Consultation Response from KC, Highways Development Management
2020/91918 rear of, 38, Occupation Lane, Dewsbury, WF13 4BP
Reserved matters application pursuant to previous permission no. 2018/93598 for outline application for erection of 3 dwellings
Date Responded:20/08/20
Responding Officer: CNB
Responding Ref:K14-7SE/20

DRG No. CS2/02 SCALE 1:100 @ A1
DRN BY M.H. DATE 15/04/20

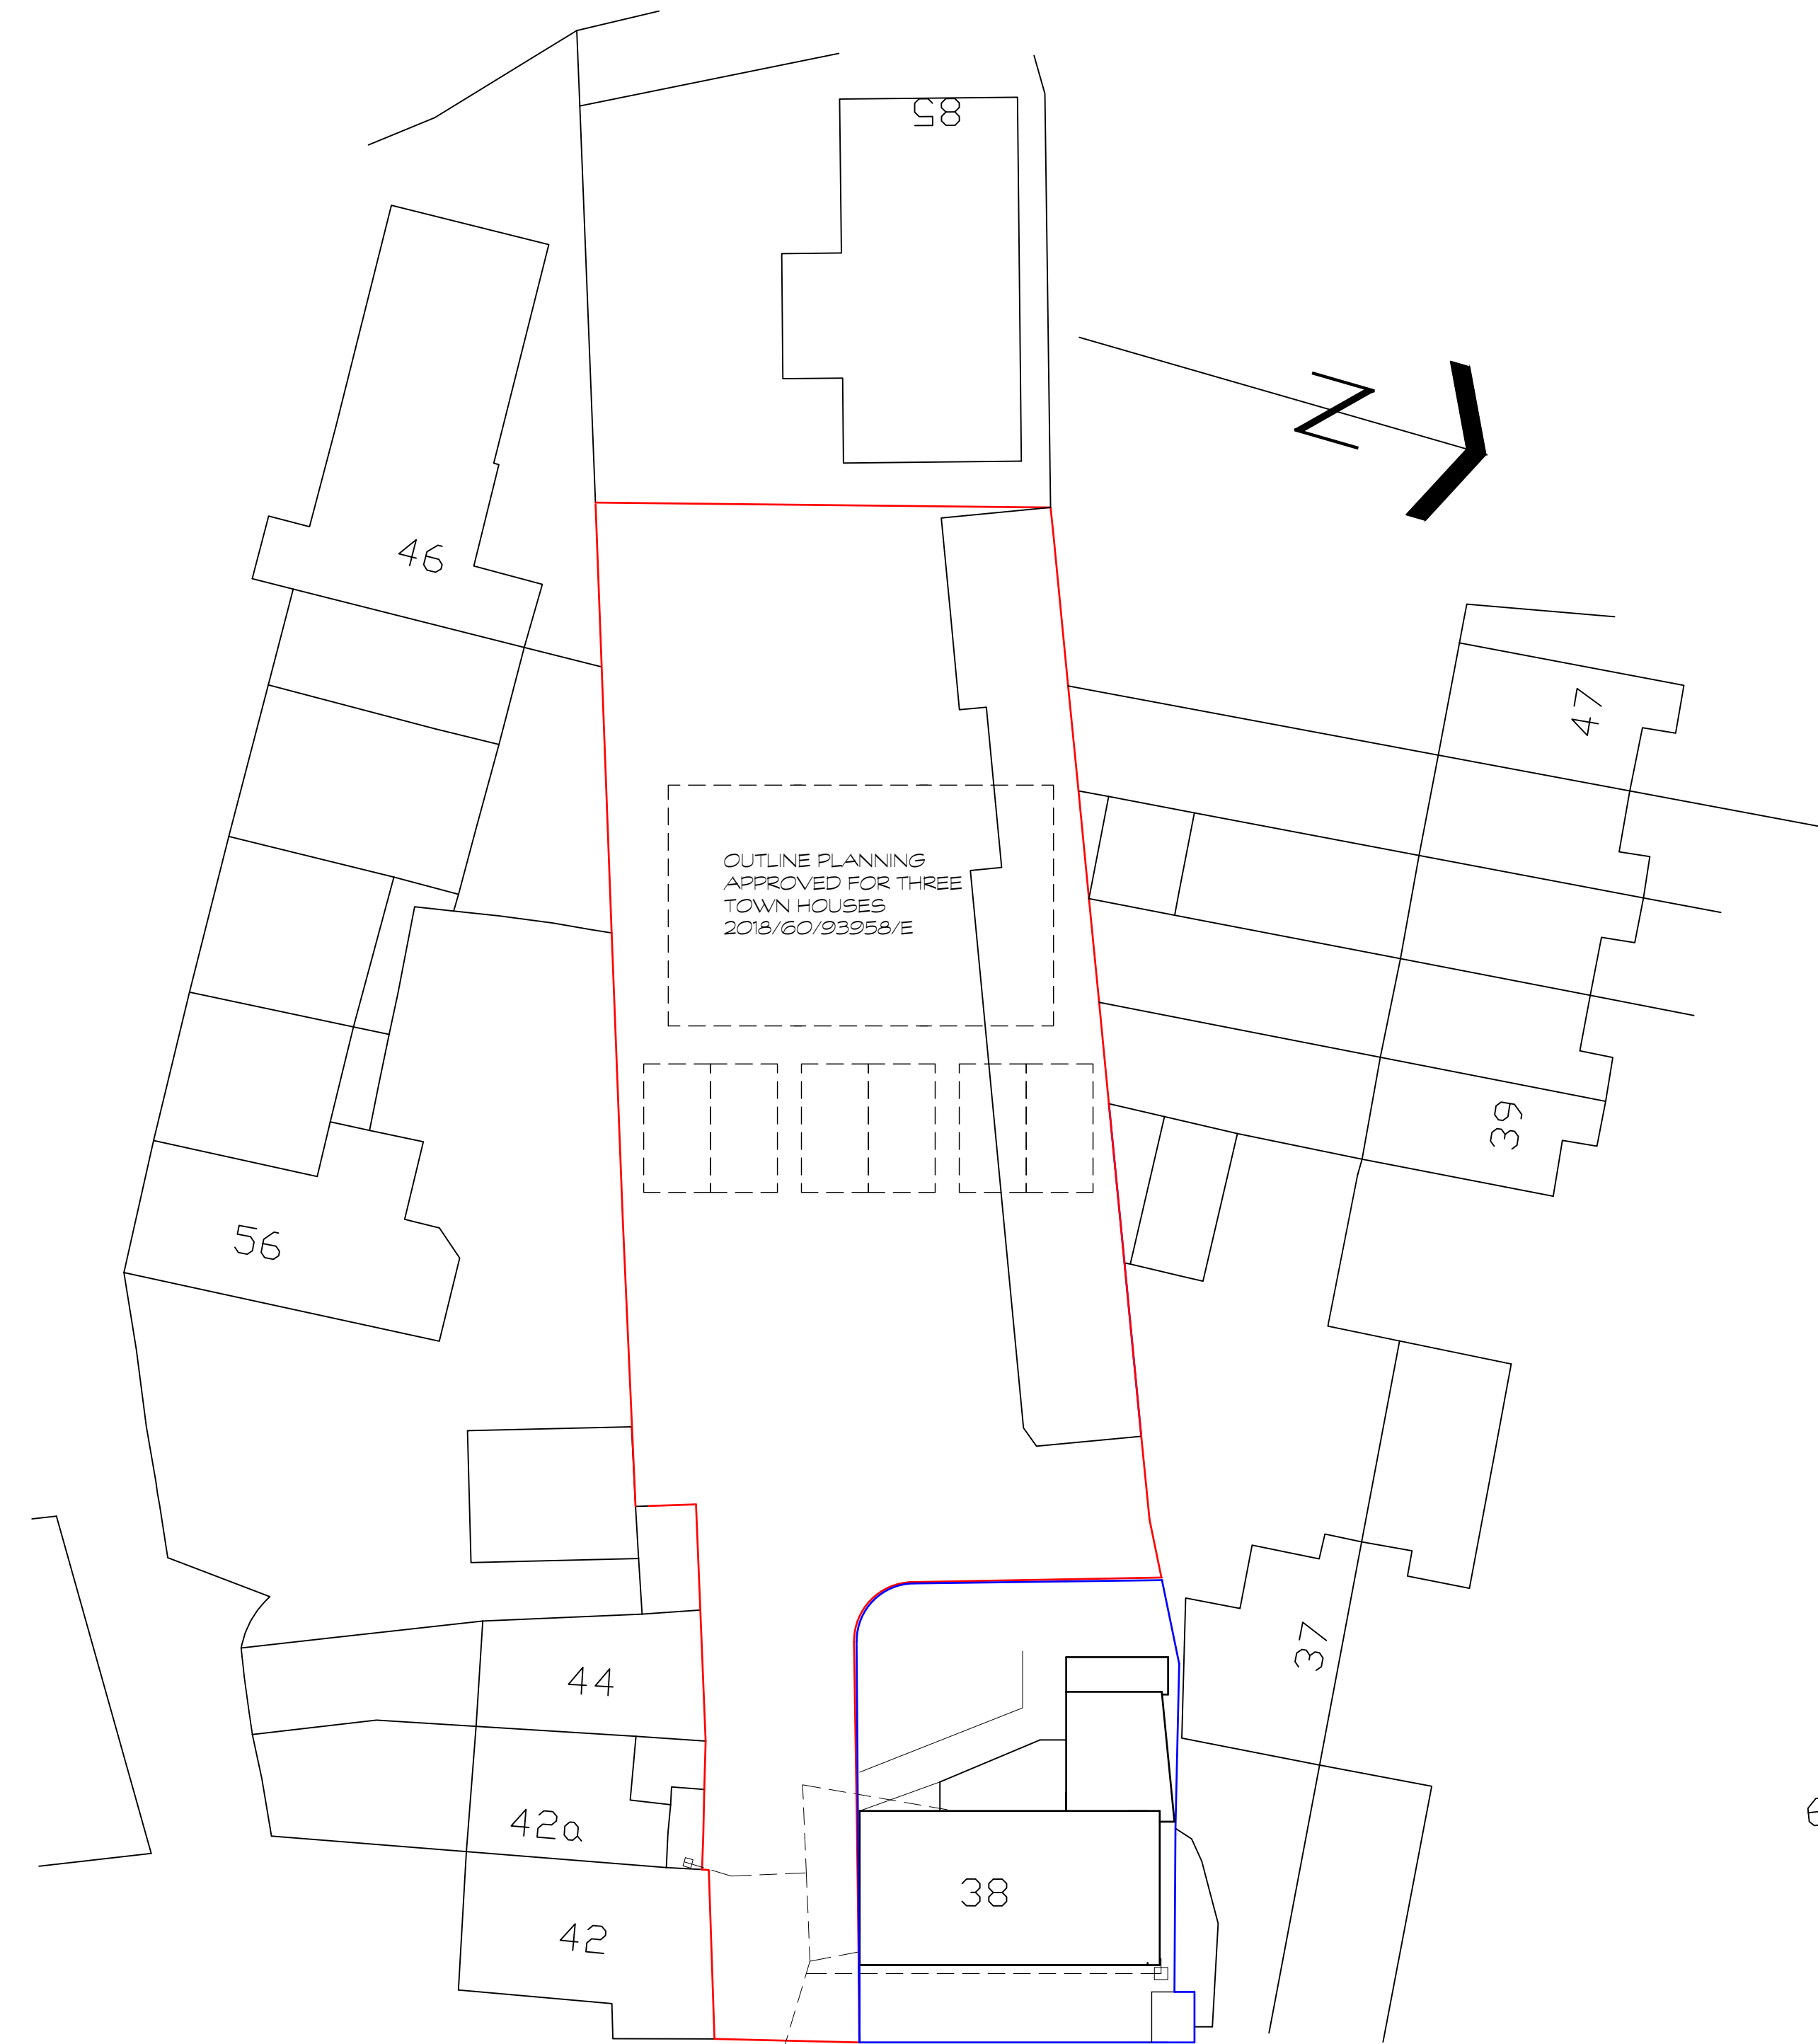
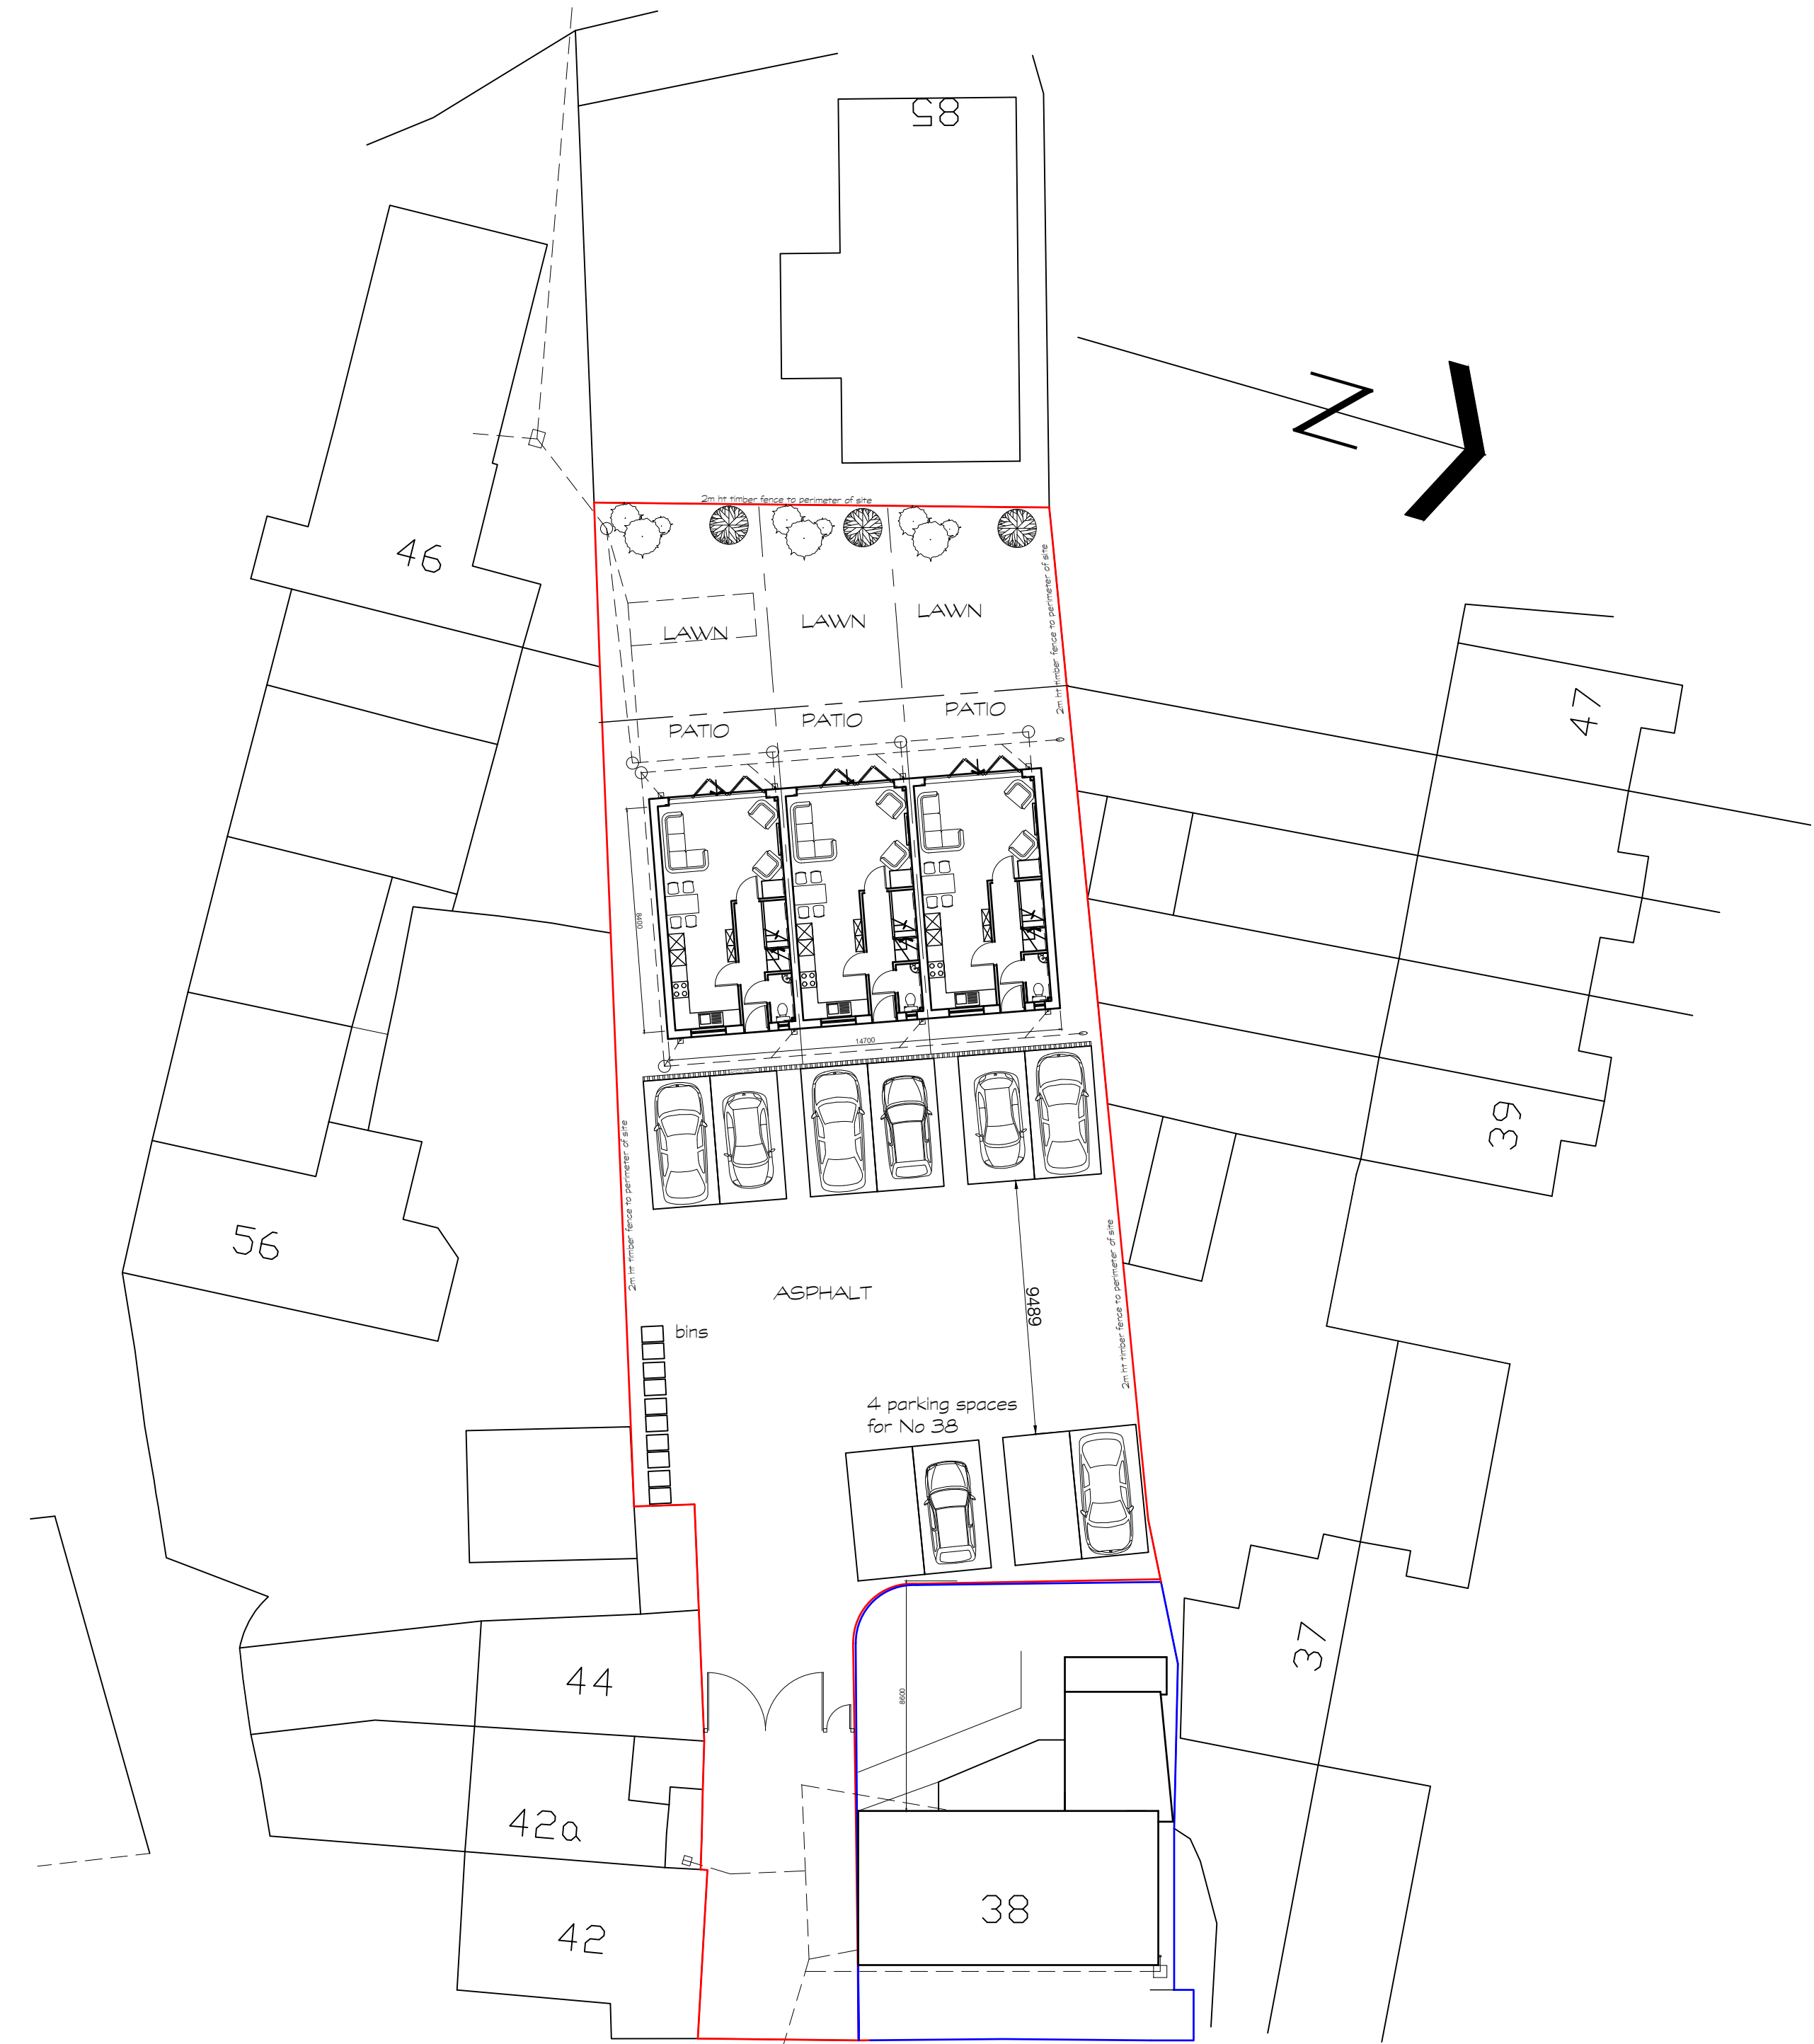
The gate across the access is situated sufficiently behind the rear of the footway as to allow vehicles waiting for it to be opened to pull clear of the highway and is acceptable. The gate should be hung to open inwards only and this should be added as a condition.

Drawing No CS2/04 indicated that the proposed dwellings are to have four bedrooms and local guidance suggests that for parking to be fit for purpose then each dwelling should have three off street parking spaces. Drawing No CS2/02 indicates only two parking spaces per dwelling and this would be against guidance. No explanation was given as to why this lower level of parking provision has been provided. Application 20/91917 also indicated 4 parking spaces for its proposals within the same parking area and this would be in accordance with guidance as the proposals are for two 3 bed properties being created, although as this would then push the number of dwellings using the spaces above 4 we would also be hoping to see a communal visitor space (as per guidance).

Based on local guidance, the total number of parking spaces required for the combined applications would be 14, three each for the current reserved matters application, four for application No 20/91917 and one visitor space. The number of spaces to be provided is 10, a shortfall of 4 spaces from local guidance. We do not think that the local highway network is suitable for this level of overflow on street parking and so we would request

that the applicant either reconfigures the parking to show a higher number of spaces on the drawing, reduces the number of bedrooms within the proposed dwellings accordingly or can provide suitable justification as to how the parking provision was assessed to reach these numbers of spaces. This should be conditioned.

Notwithstanding the provisions of the Town and Country Planning (General Permitted Development) Order 1995, (or any order revoking and re-enacting that order) any gates or barriers for or over a vehicular access or egress shall be set back from Occupation Lane as shown on drawing CS2/02 and shall be hung as to only open inwards. So long as such gates or barriers are in position they shall be retained to only open inwards.

Notwithstanding the details shown on the approved plan, no development shall take place until a scheme detailing arrangements and specification for layout and parking have been submitted to and approved in writing by the Local Planning Authority. Before any building is occupied the development shall be completed in accordance with the details shown on the approved plans and retained thereafter.
